Application number: 2020/93470	
What is the application for?:	Outline application for erection of residential development
Address of the site or building:	Land Off, Upperthong Lane, Upperthong, Holmfirth, HD9 3UZ
Postcode:

Type of comment: An objection

REV	DATE	DESCRIPTION
PROJECT		
UPPERTHONG LANE, HOLMFIRTH		
TITLE		
PROPOSED ACCESS AND VEHICLE TRACKING		
SCALE		
1:250 @ A1		
DRAWING		
1895-101		
DATE		
09.11.2020

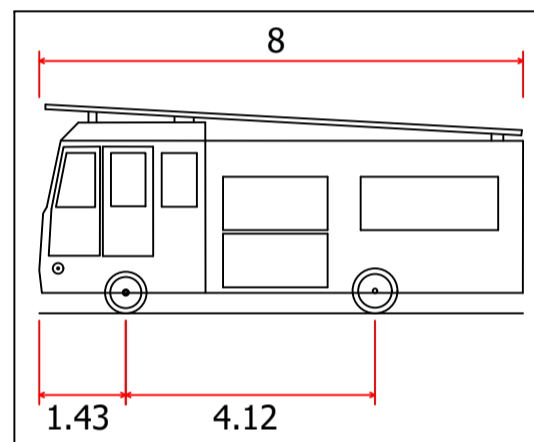
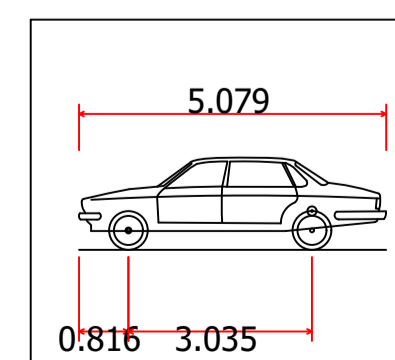
The proposed access to the site is narrow and has reduced visibility. The roads in the area have already become much busier in recent years and it is becoming less safe for children and pedestrians to walk along the roads as there are very few footpaths nearby. The increased traffic flow and concealed entrance will further increase the danger to pedestrians.
